**WEST SUSSEX COUNTY COUNCIL
STRATEGIC PLANNING CONSULTATION**

SUBJECT: LU/121/17/RES - Approval of reserved matters following outline consent LU/47/11/ for construction of 126 No. dwellings together with internal road network, car parking & landscaping.

LOCATION: Land North of, Toddington Lane, C1 & part Parcels B2, B4 & C2, Littlehampton, West Sussex, BN17 7PP.

This is the second WSCC highways and transport response to the above planning application and responds to the additional information provided by the applicant. Drainage comments will again be made separately by the drainage engineer.

GENERAL ARRANGMENT DRAWING (1 OF 2)

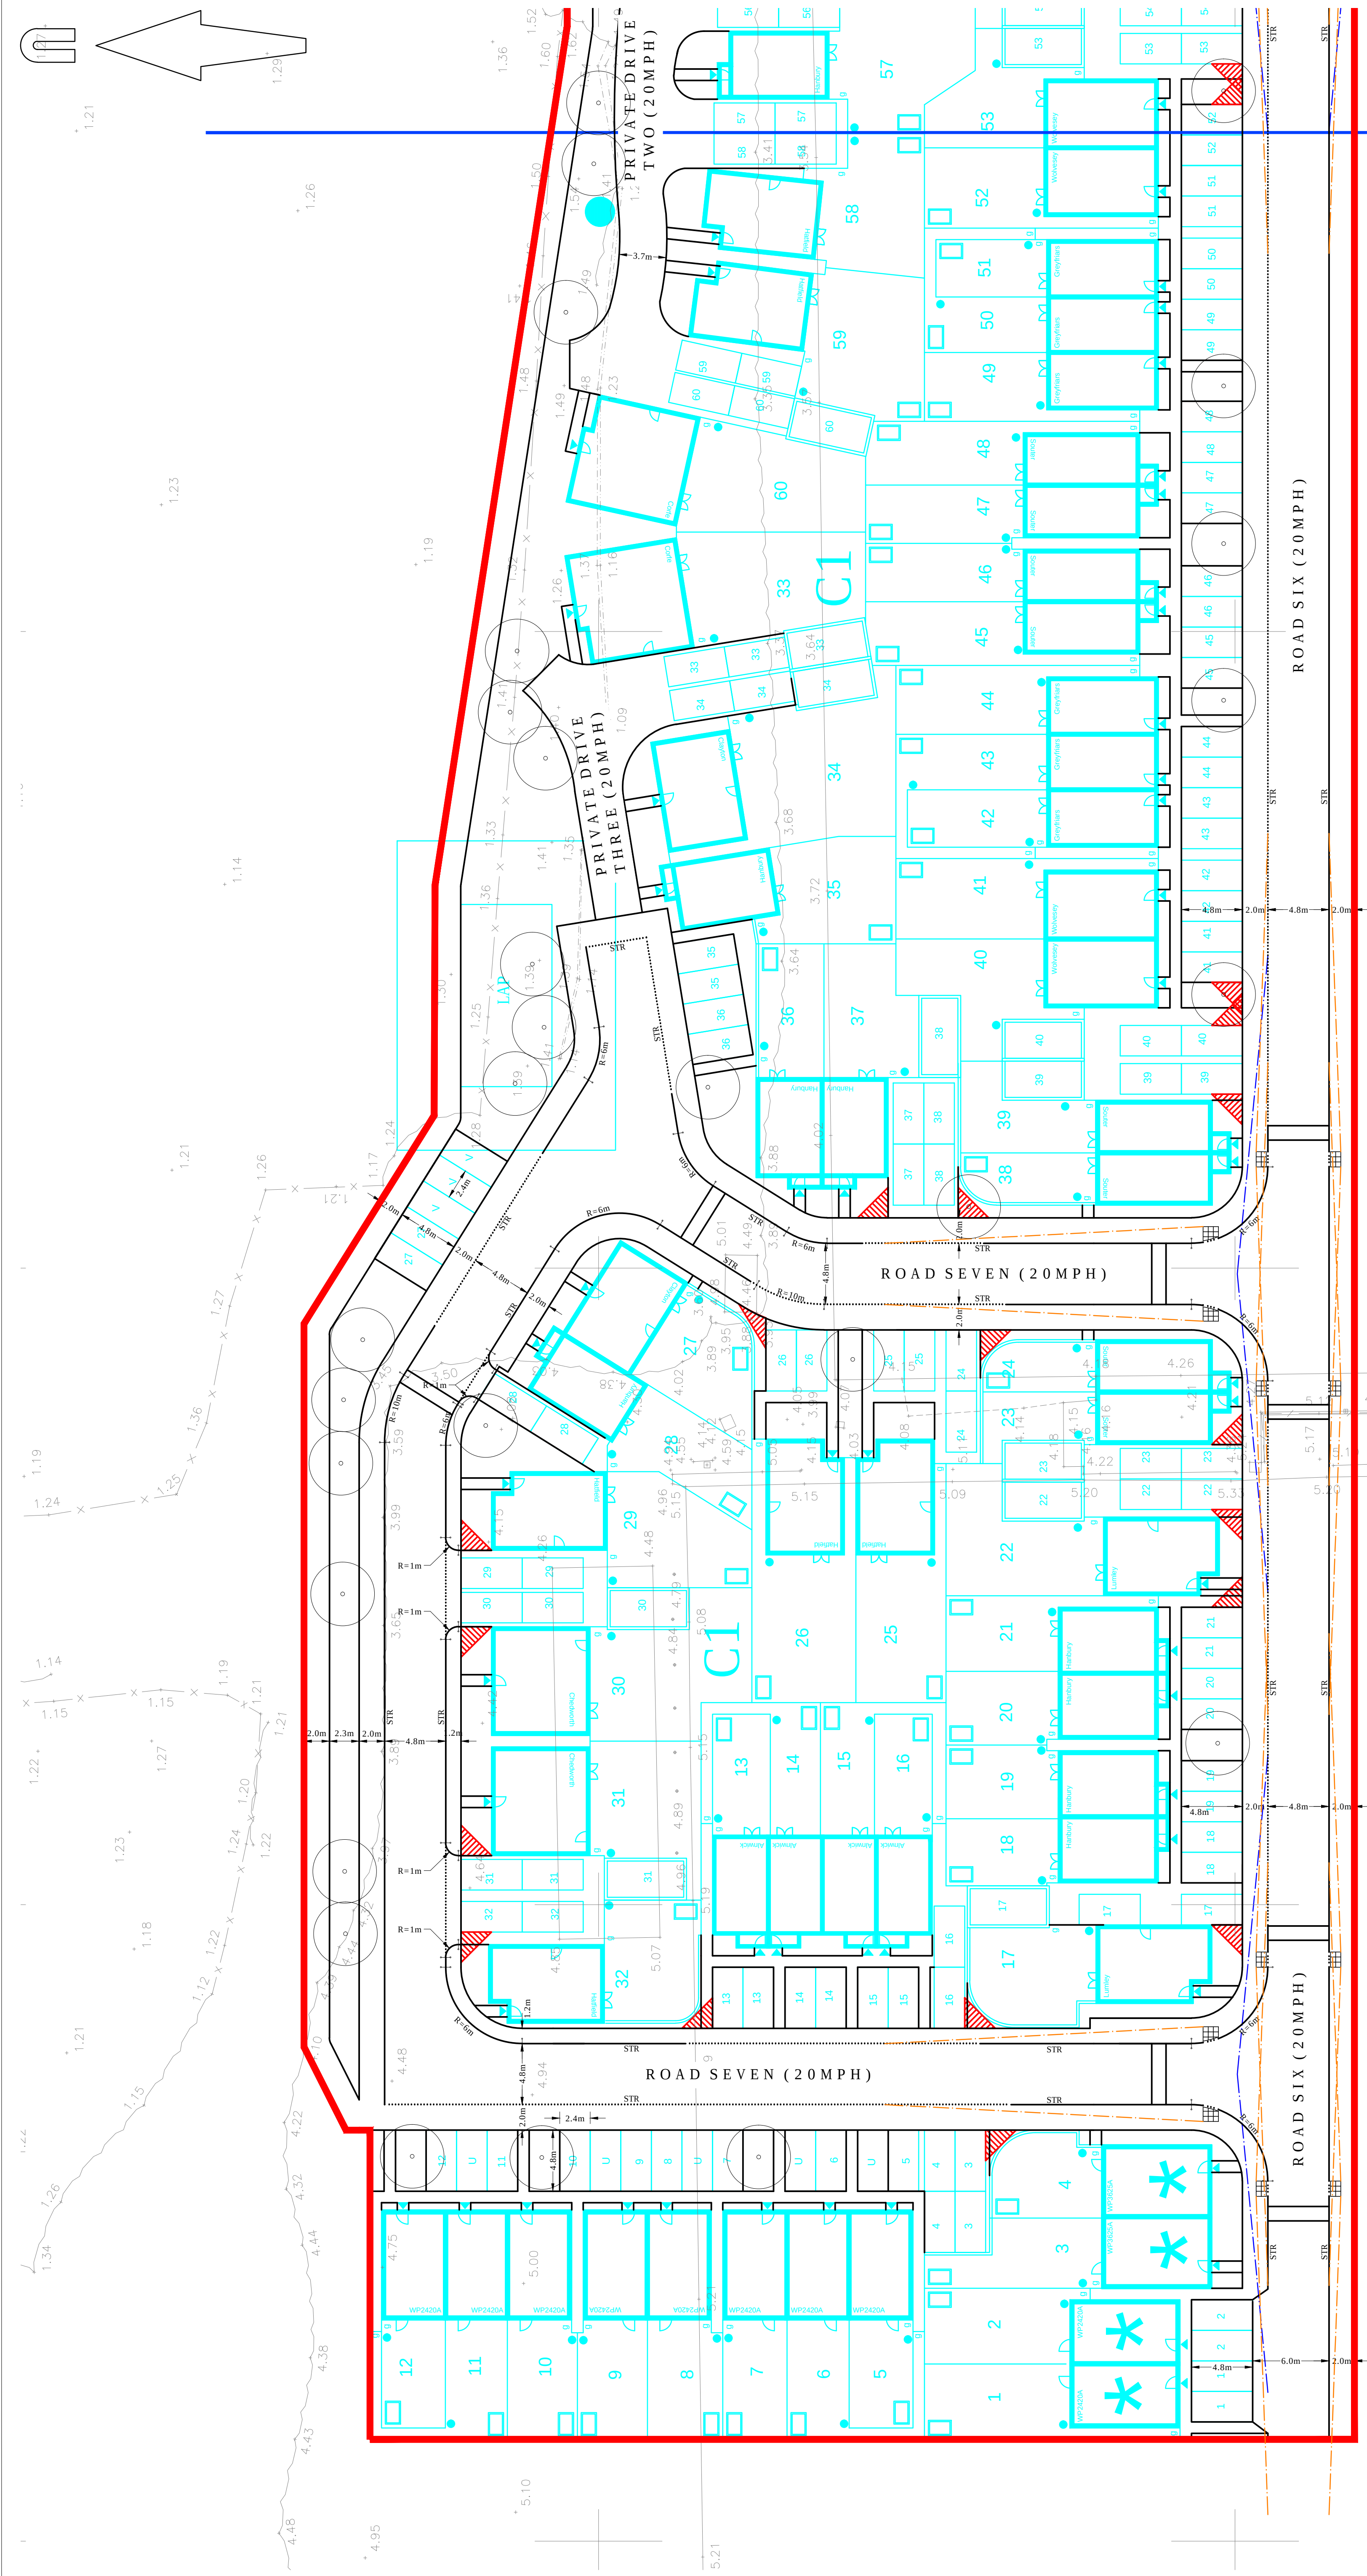
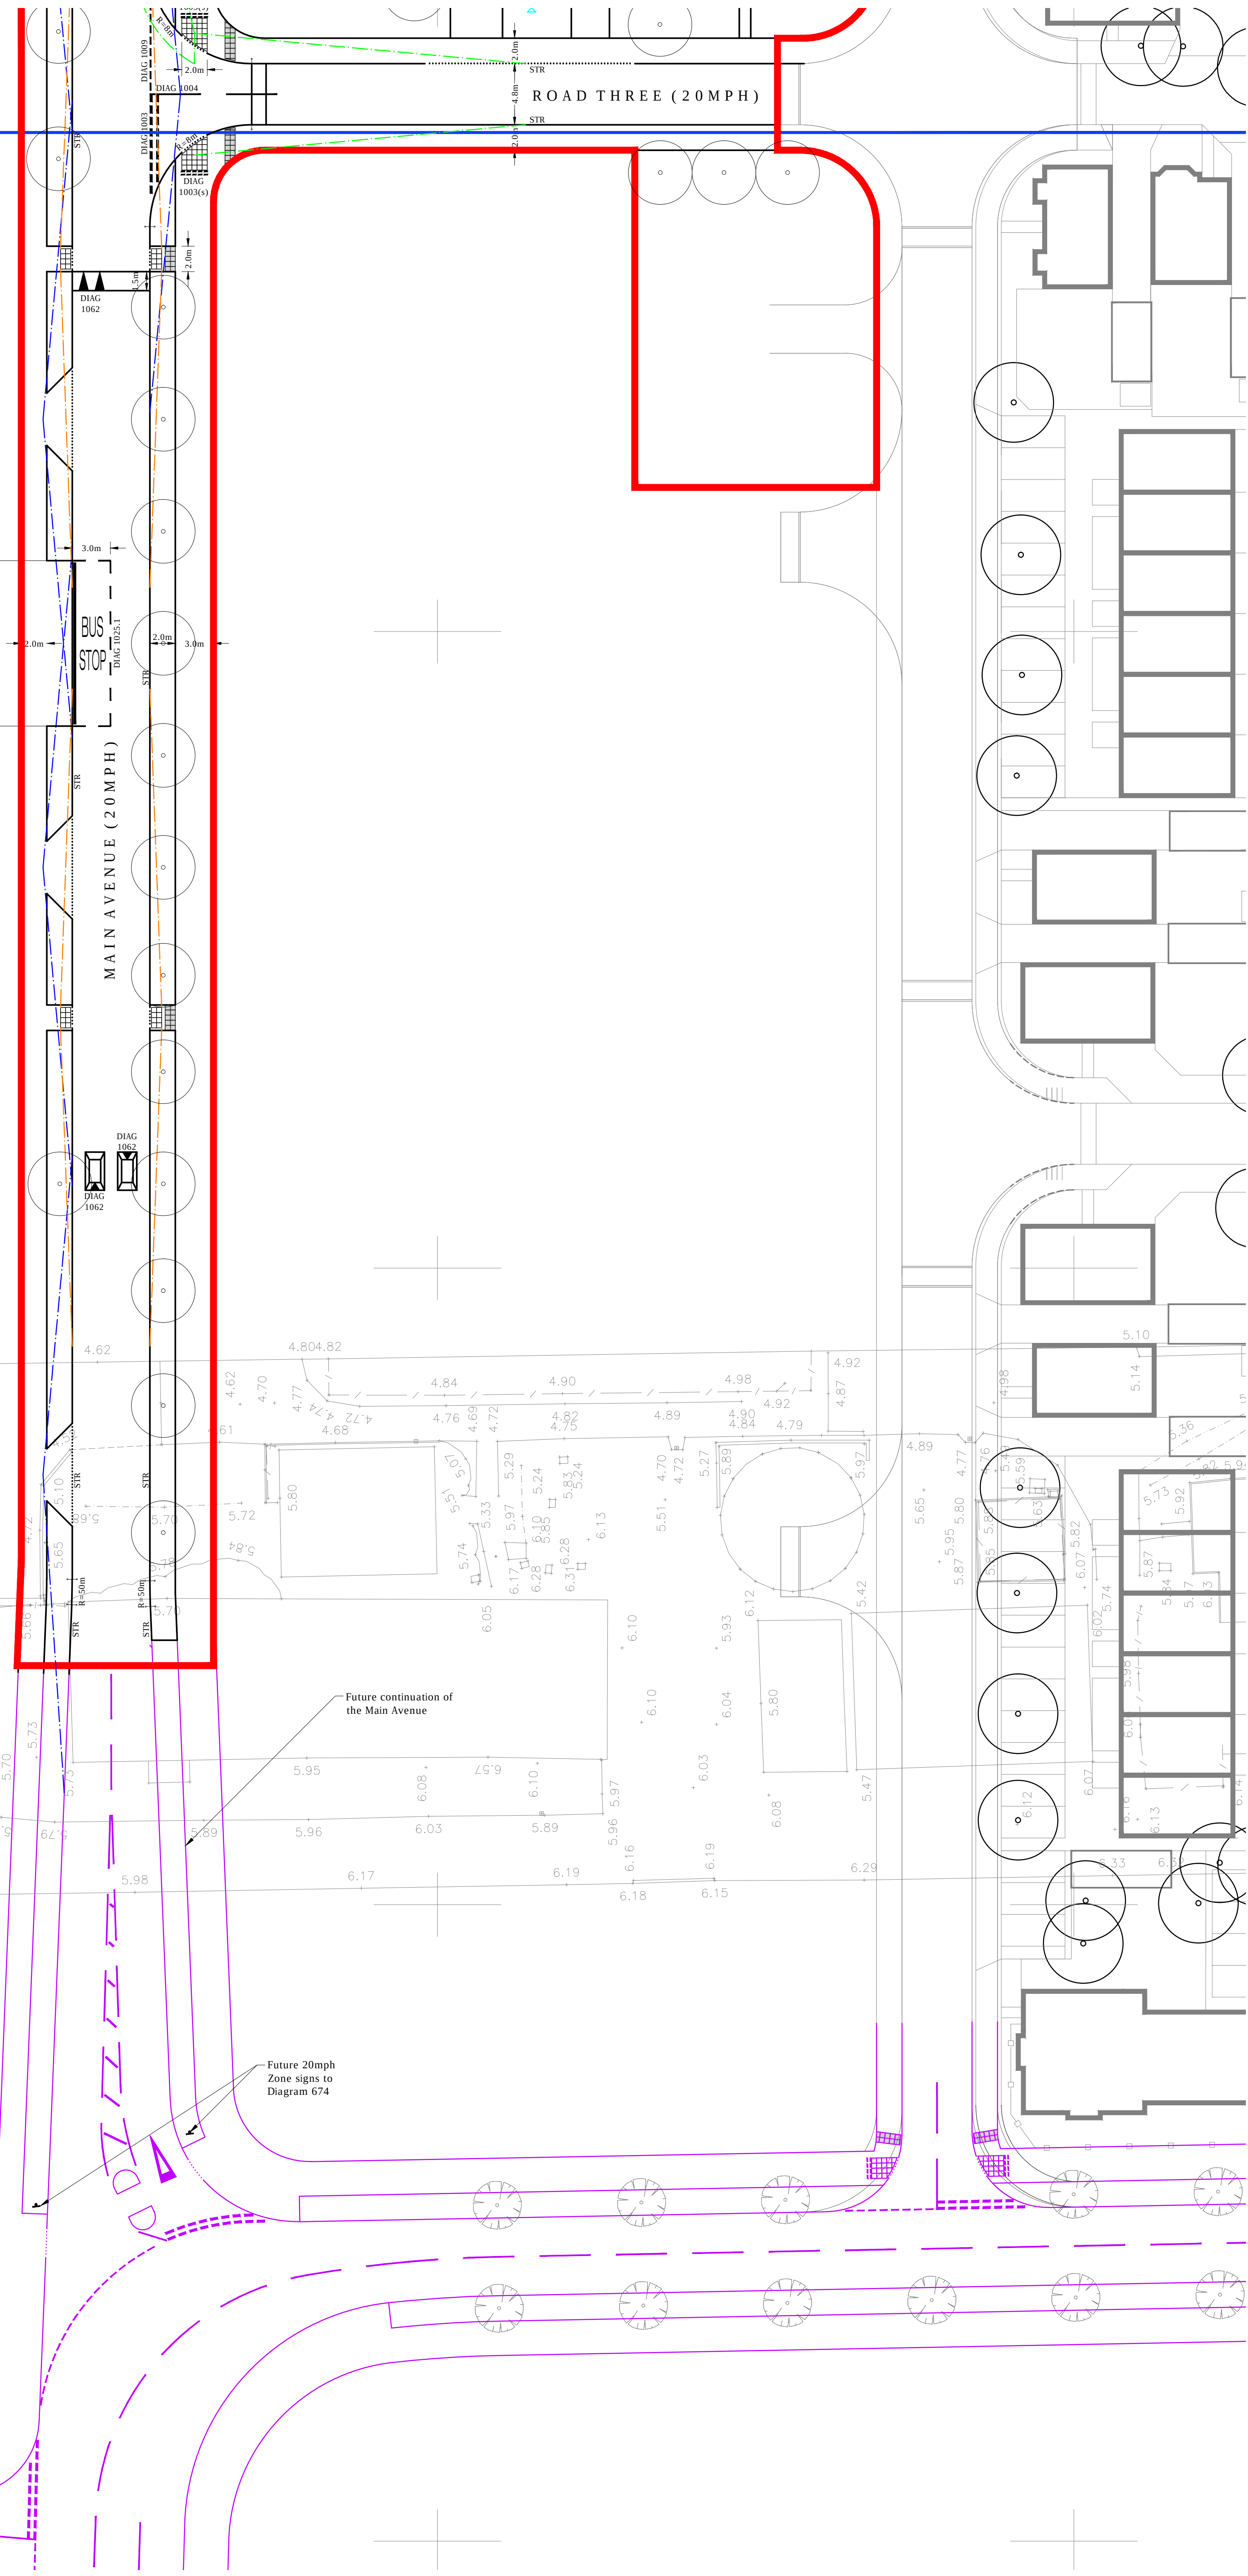
Widths – The main ‘avenue’/spine road running into the development appears to measure 6.1m wide which is suitable for large vehicles to pass one-another on straight sections subject to no obstructions being present (e.g. parked cars etc.). For parts of the road to be built in the future that have curves and/or bends, tracking diagrams will be required to determine suitability of any carriageway widths proposed. All other roads proposed within the application limits appear to measure 4.8m wide (other than for some short lengths providing access to plots 33-35 and 61-64 where these are shown as informal private driveway arrangements). Entrances to parking courts serving plots 95-100 (Apartment Block A) and plots 117-122 (houses) measure 4.1m wide at the actual crossing points to and from the estate roads. After that, the accesses serving these properties widen-out to 6.0m to permit manoeuvring in and out of car parking spaces.

Visibility splays – Need to be appropriately shown in accordance with relevant guidance at all junctions and where driveways join carriageways (including consideration of landscaping and demonstration that planting etc. does not obstruct visibility splays). Some are shown but not all. Please amend. All splays to comply with road design speeds.

Tree planting into Granite Setts on Main Avenue - Plan
Scale 1:50

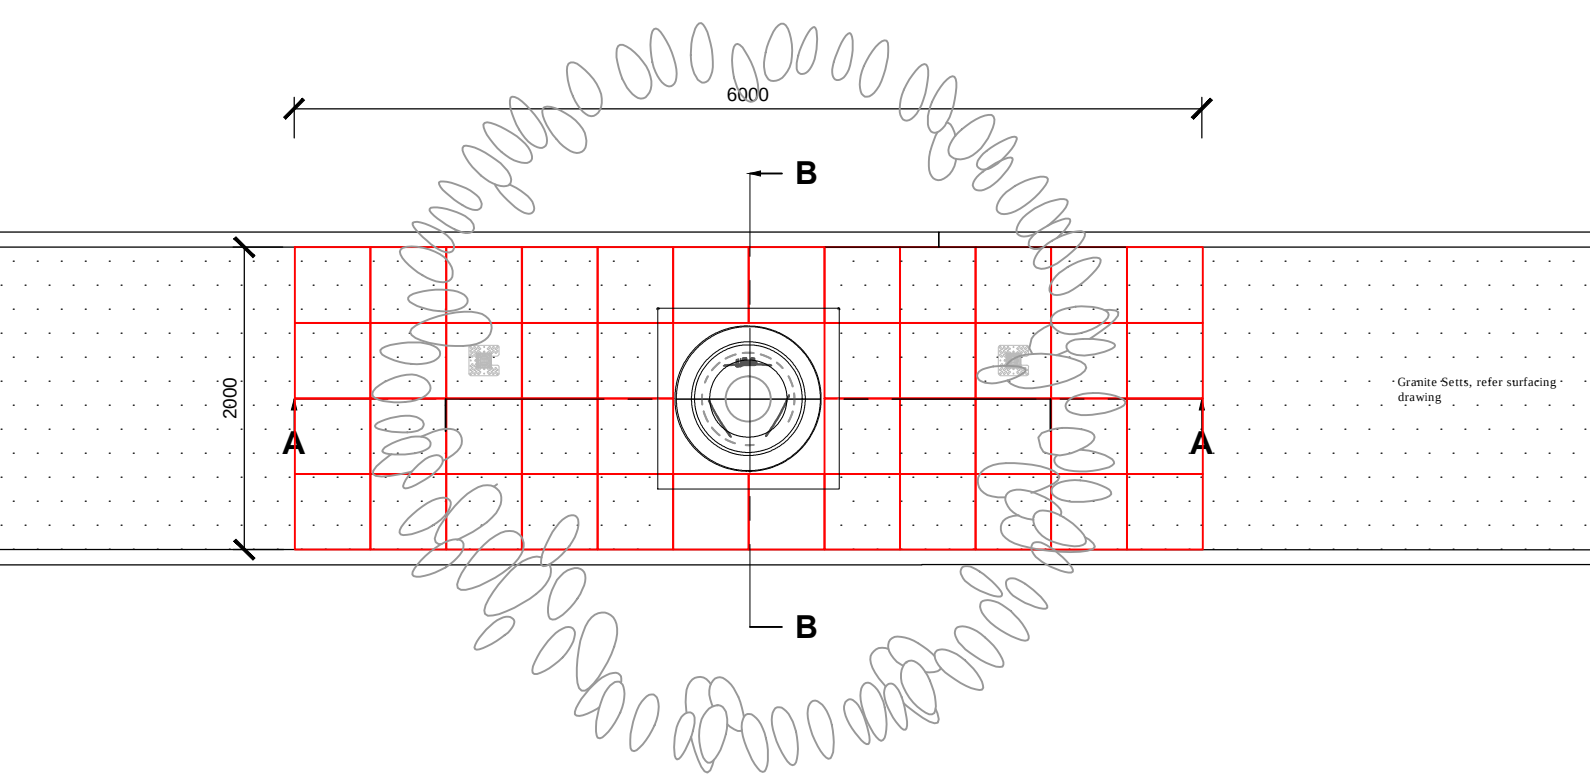
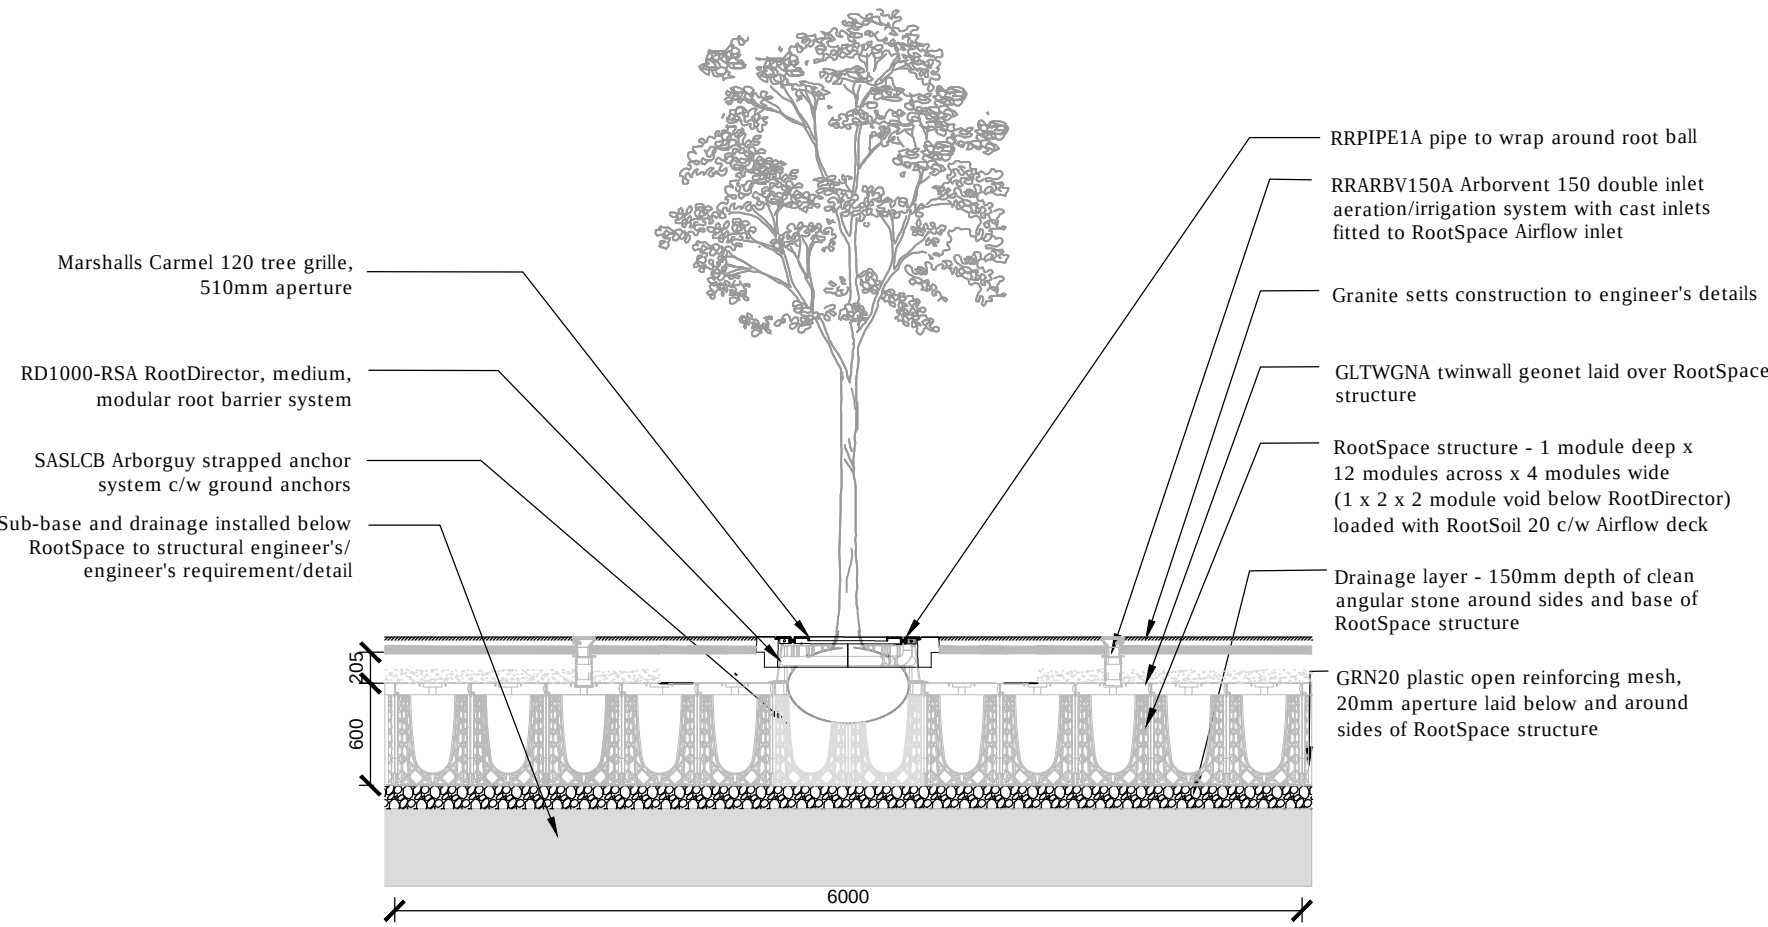
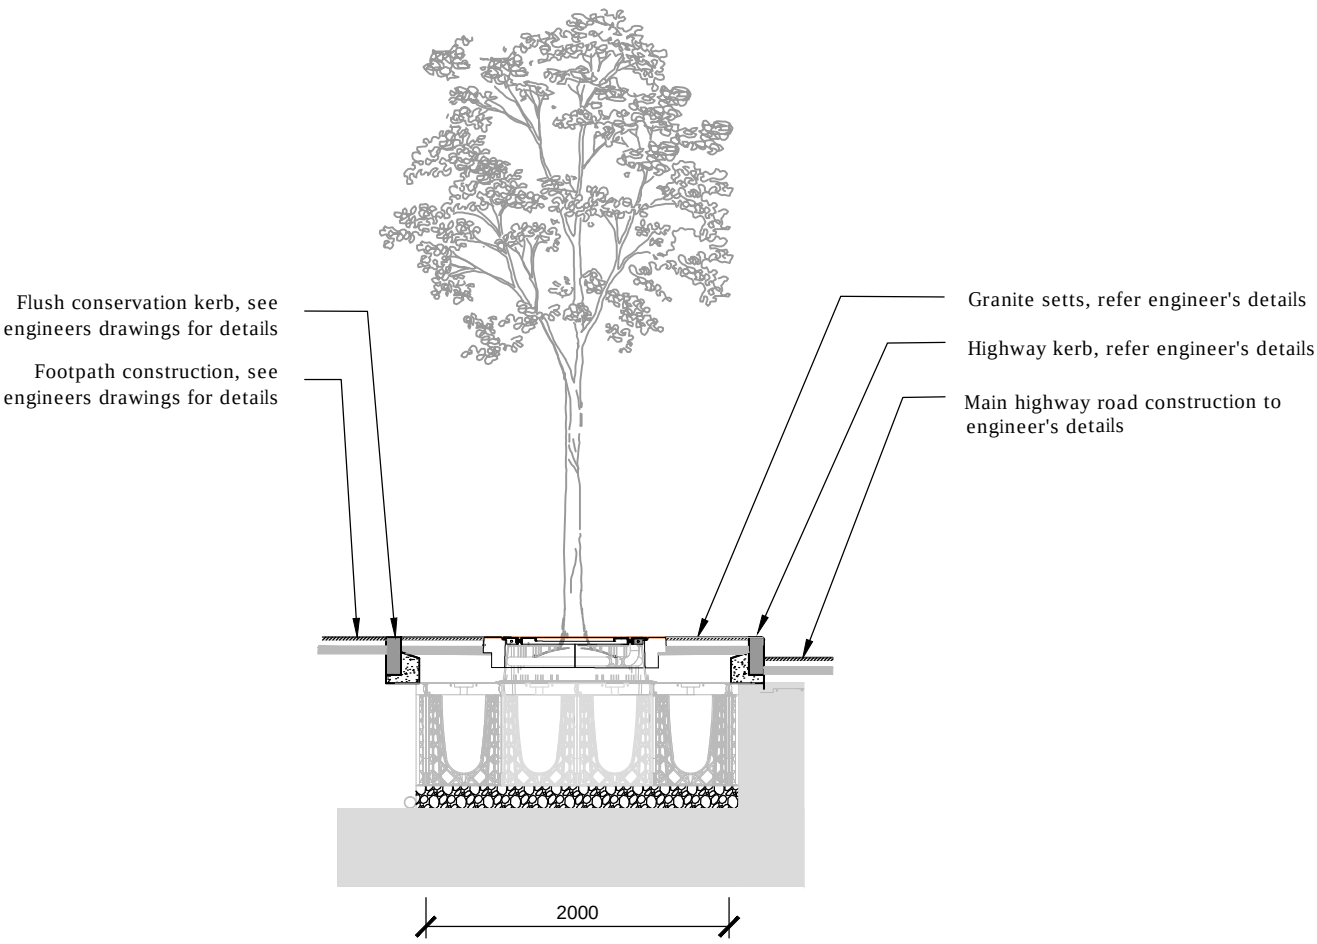
With regard to hard landscaping (granite setts with trees pits adjacent are shown for parts of the main spine road leading into the development from the IDR), this type of treatment should be removed and replaced with grass. Granite setts are potentially a safety hazard if pedestrians choose to cross over them, a maintenance liability and can create issues with tree growth adjacent.
